From: [REDACTED]
Sent: 10 January 2018 21:36
To: Planning.Responses
Cc: Deborah Urquhart
Subject: Highways Response A/155/17/OUT

SUBJECT: A/155/17/OUT- Outline application with some matters reserved for 3 No. dwellings. This application may affect the setting of a Listed building & is a Departure from the Development Plan.

Avenals Barn, Water Lane, Angmering, West Sussex, BN16 4EP

- Amendment A**
1. Gardens increased to 10m
 2. Right of way included to Weavers Hill
 3. Patio door removed from front elevation, replaced with 2No. windows

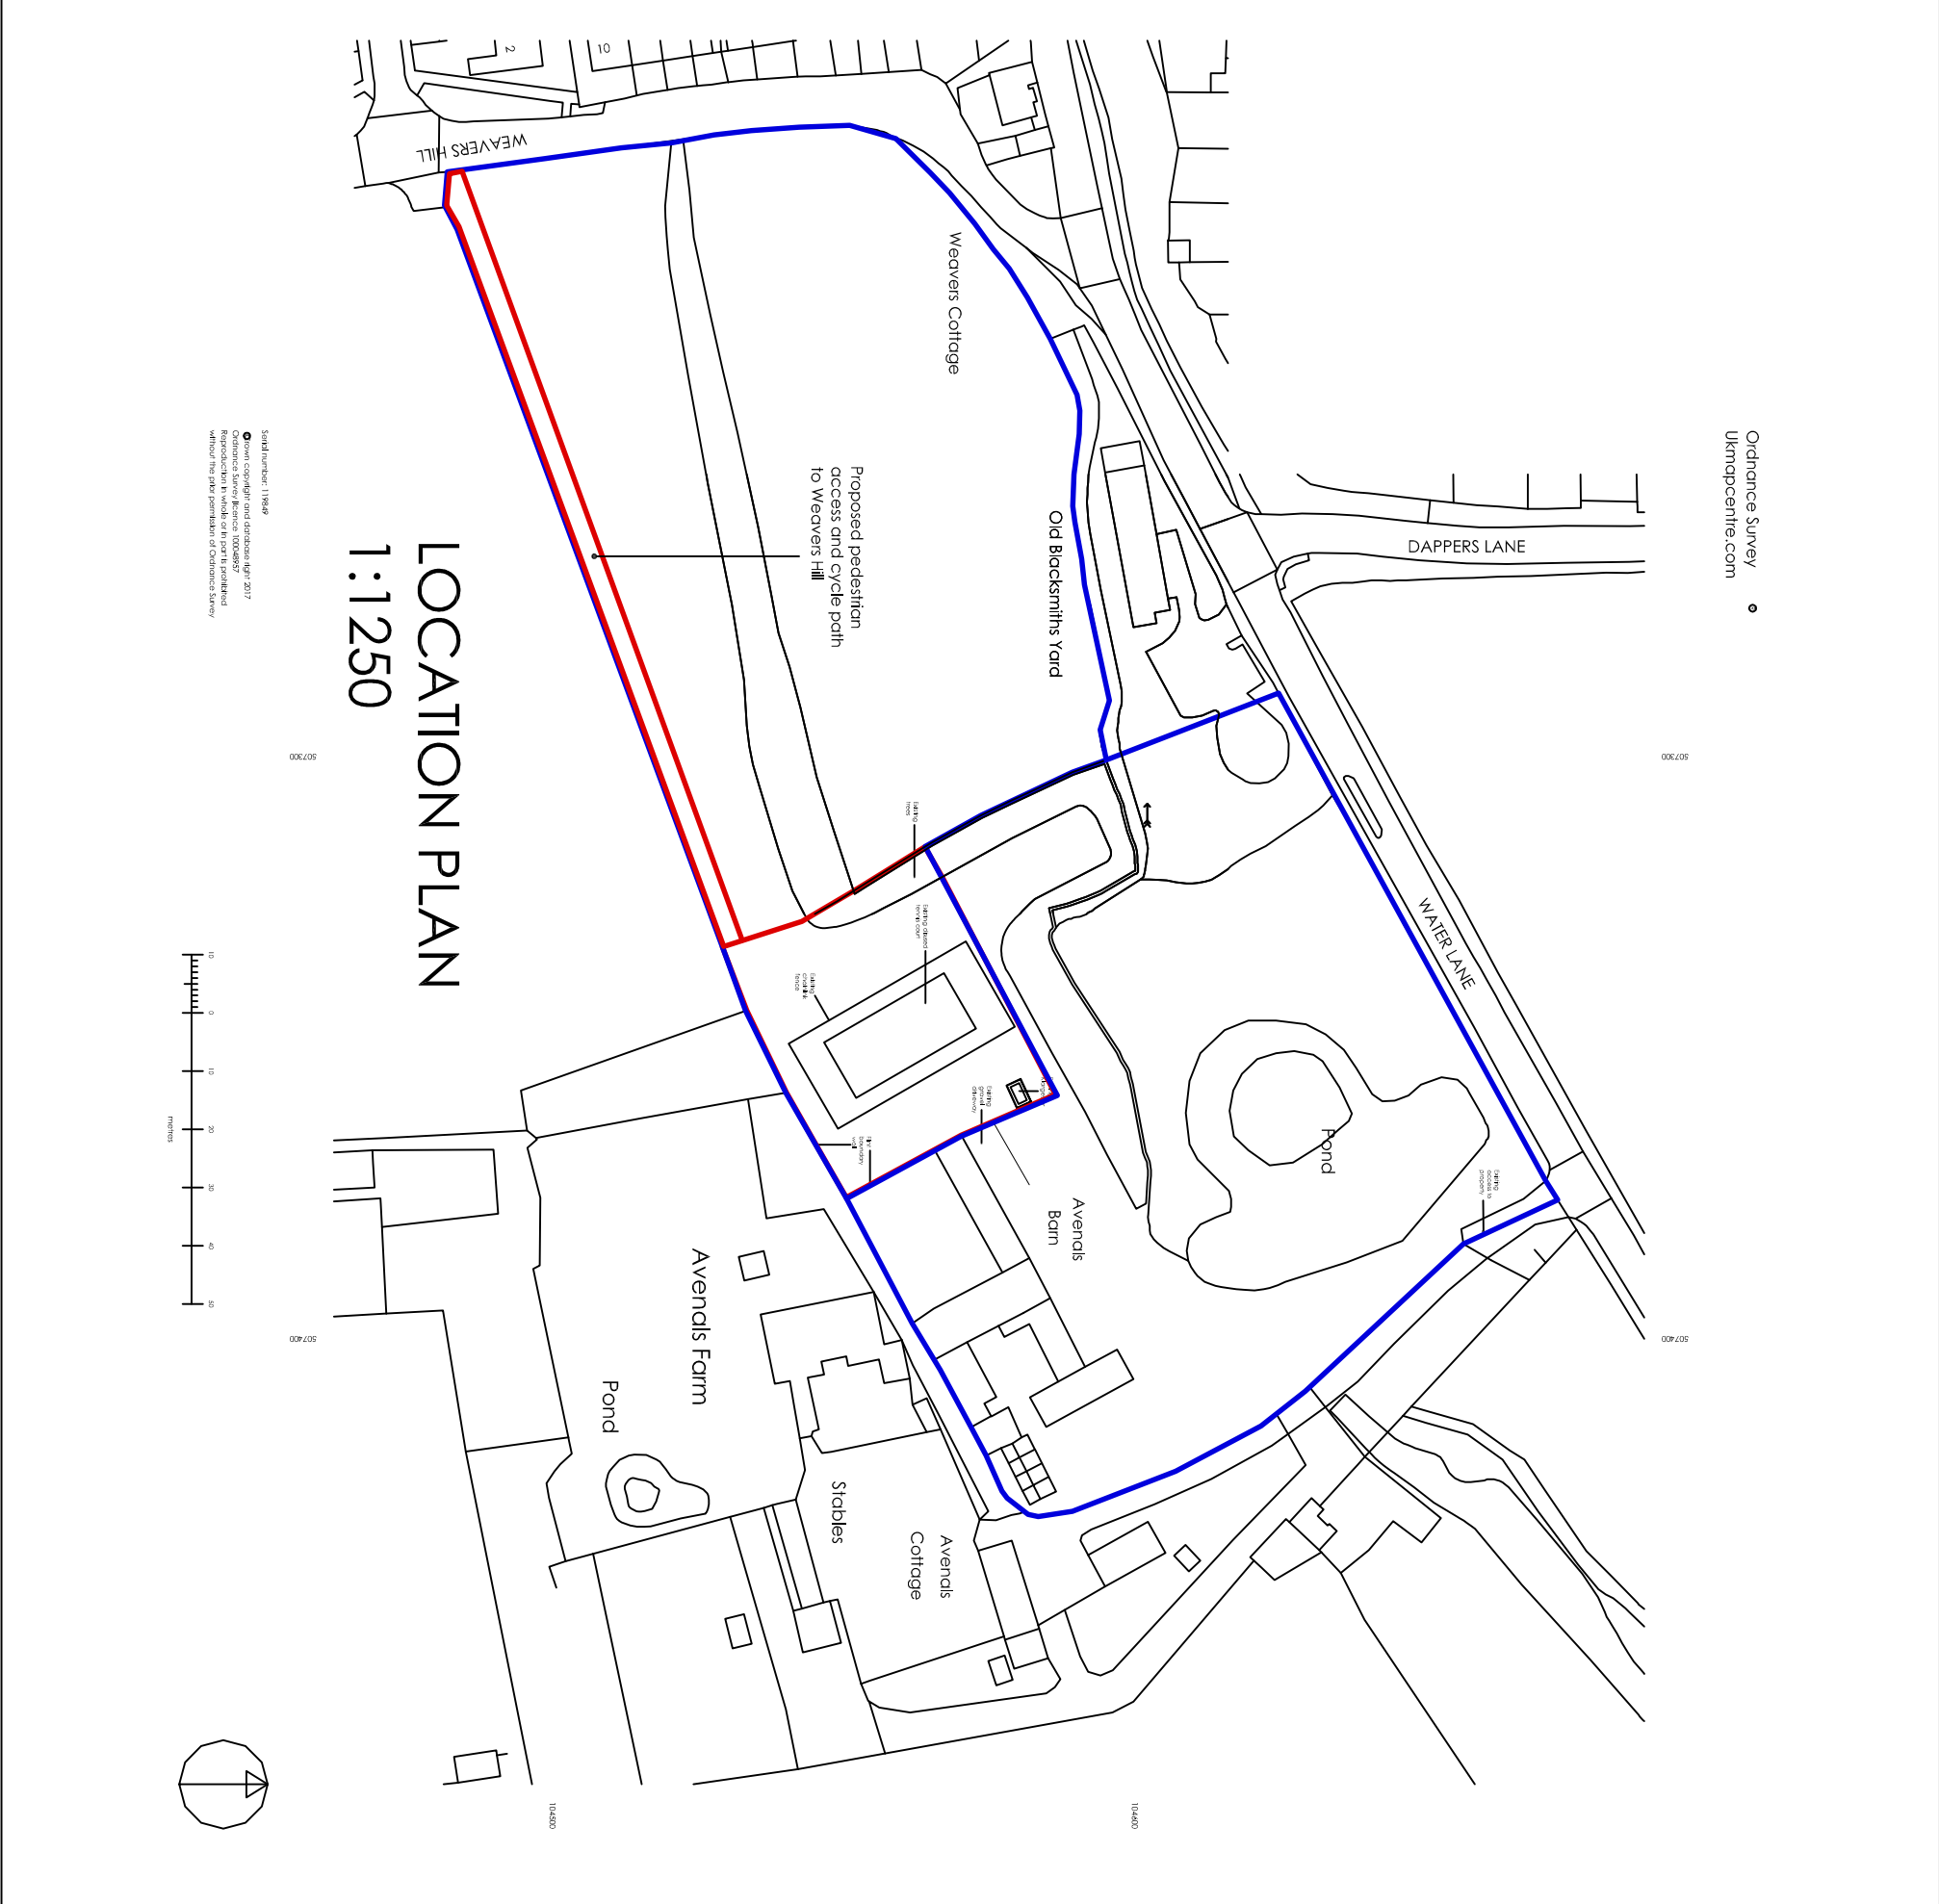
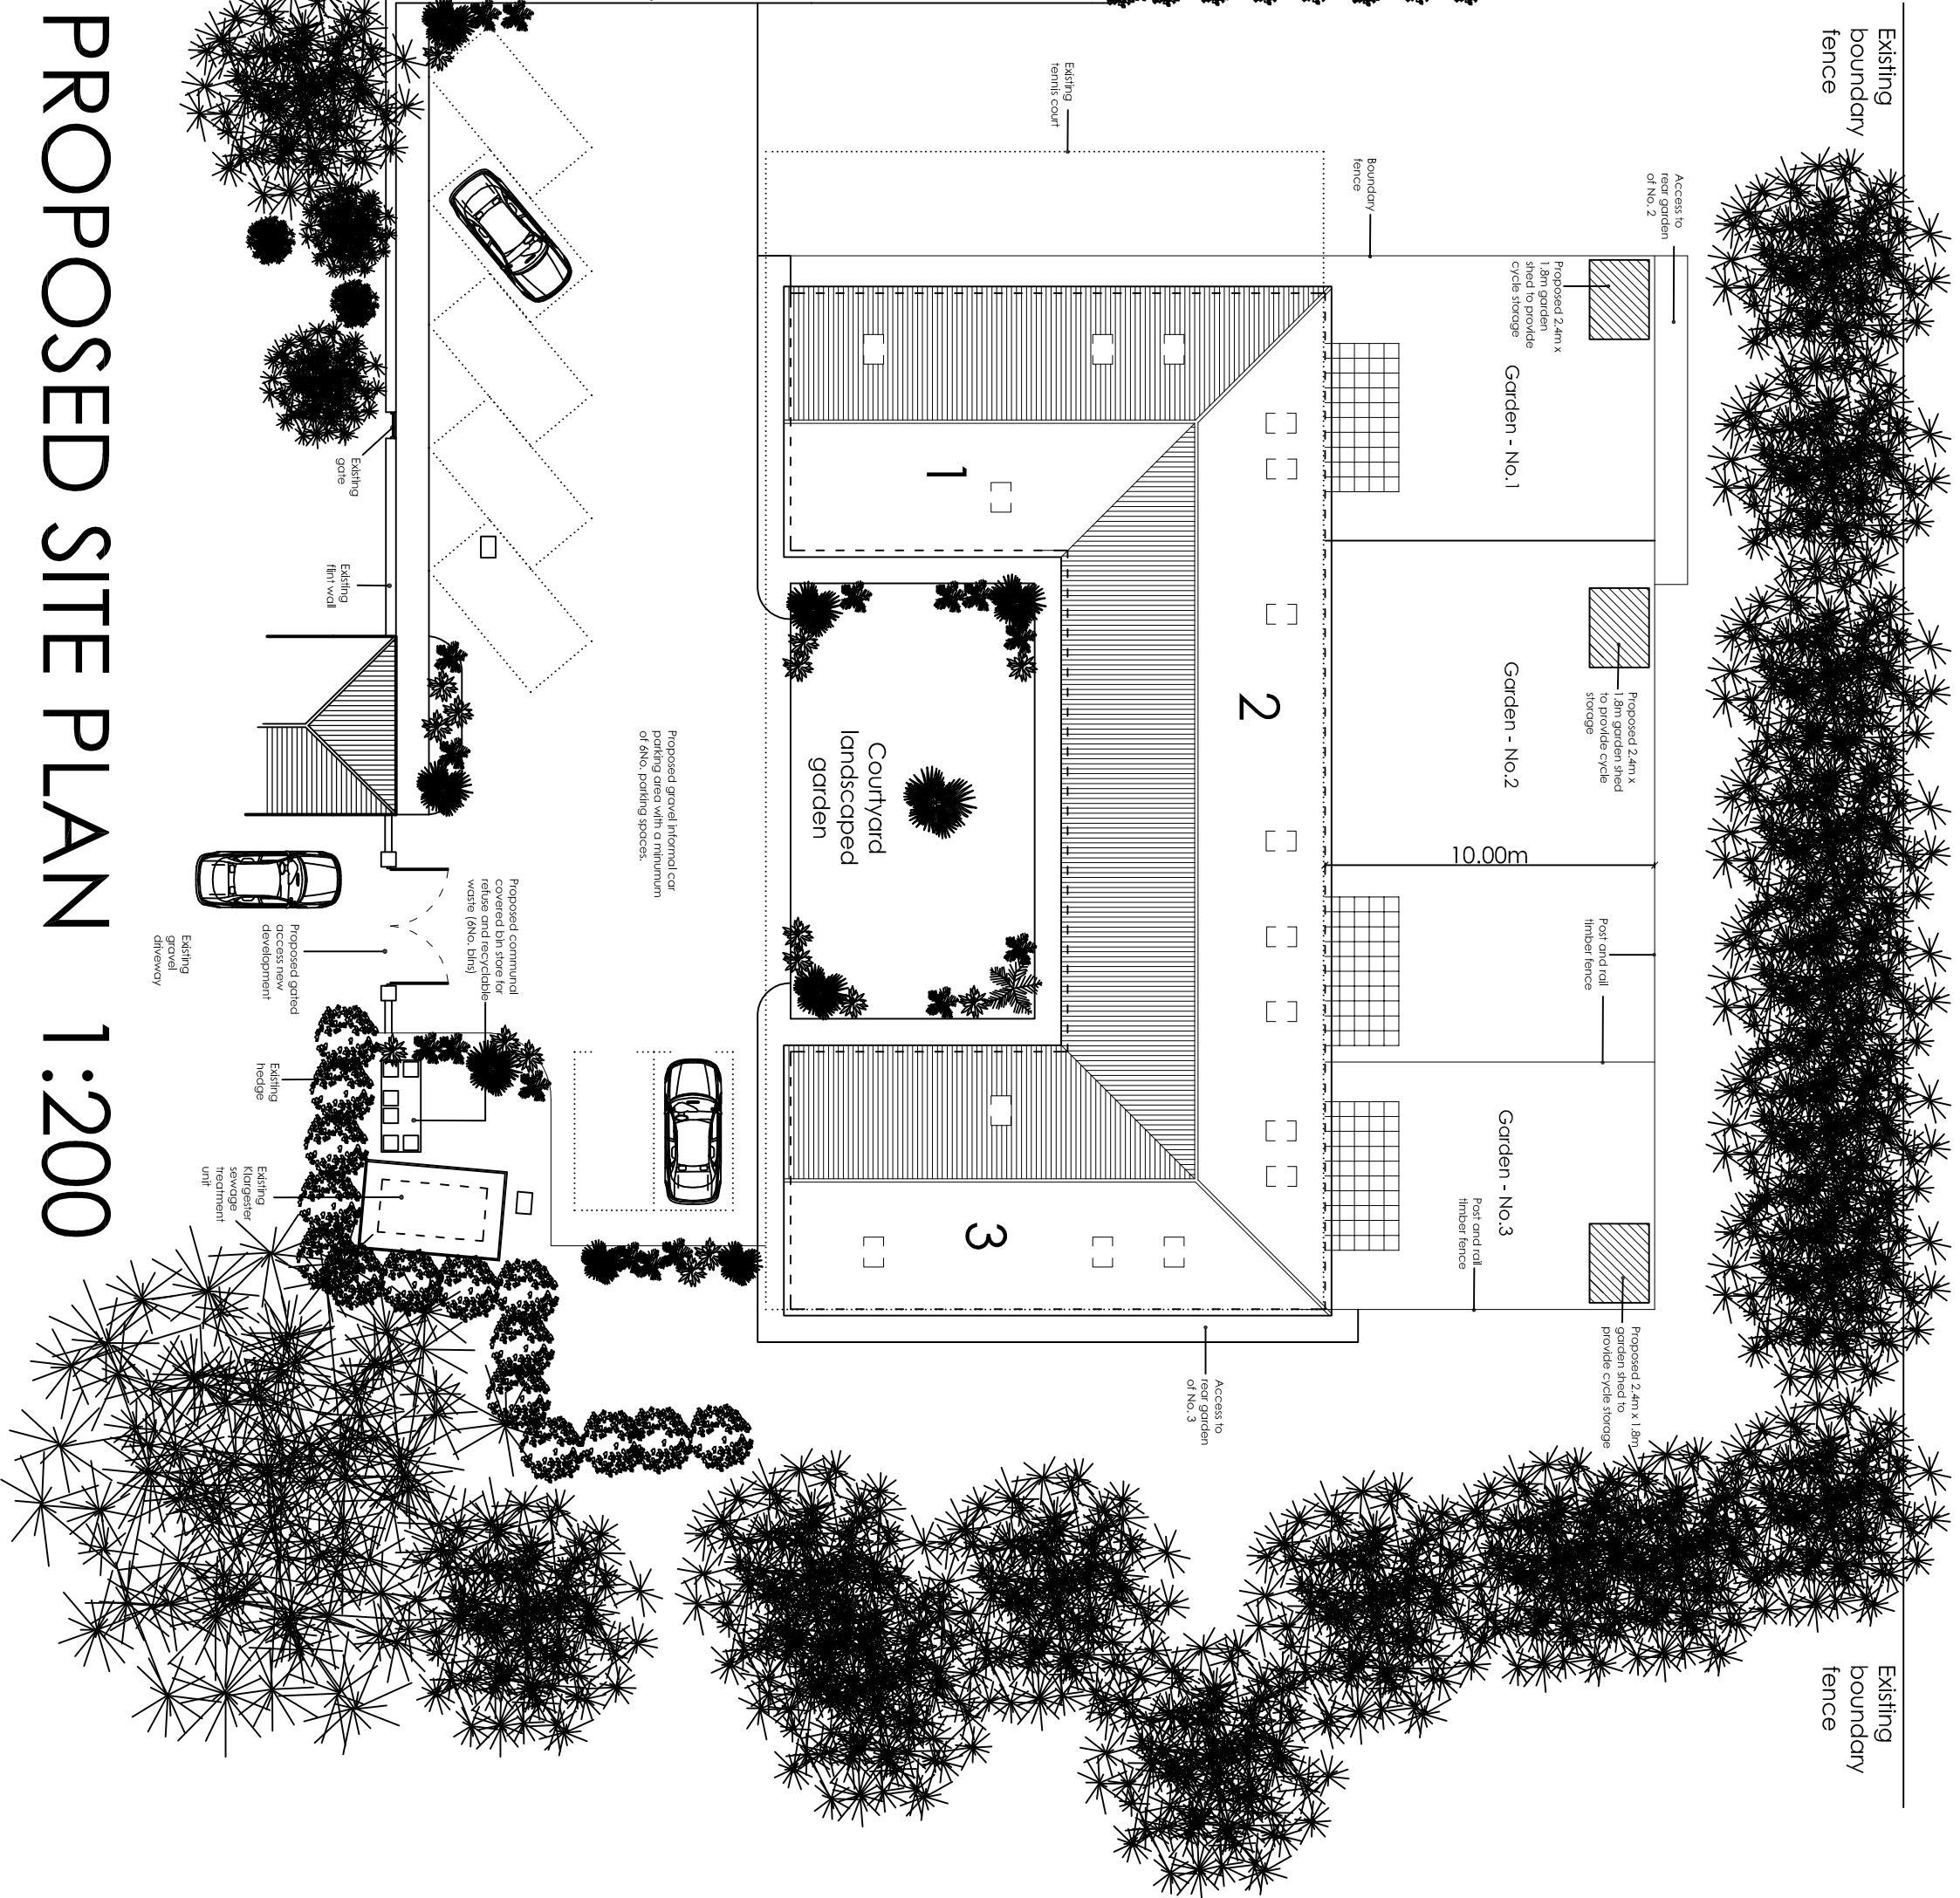
The amended plans outline that there is a proposed formalised pedestrian access linking Avenals Farm with Weavers Hill. Weavers Hill is not served along its length with pedestrian footways however it is street lit at the junction to Cumberland Road which also provides footways for pedestrians.

The proposed pedestrian access would benefit from being integrated with the existing footway network which is present on the opposite side of Weavers Hill at the junction with Cumberland Road; this would provide a more fluid link with the existing network. However the Local Highway Authority (LHA) is required to consider the size of the development proposed and potential use of the pedestrian access which is anticipated to be infrequent as the link would be only be required for residents of Avenals Farm.

Although the proposed footway does emerge at a point that does not link with the existing network, it is considered that the bus stop present 5m south of this location currently operates on a similar arrangement and upon checking Sussex Police Collision data, has operated safely for some time.

The LHA advises that any pedestrian access is built to a minimum of 1.5m in width. This measurement is in line with the guidance set out within The Department for Transport's Inclusive Mobility documentation. This states that 1.5m is sufficient for a wheelchair user and an ambulant person to walk side by side. This pedestrian access is advised to be surfaced with a bound material to prevent any overspill being dragged into the carriageway at Weavers Hill.

It is presumed by the LHA that the pedestrian access is to remain within private ownership and be maintained accordingly.
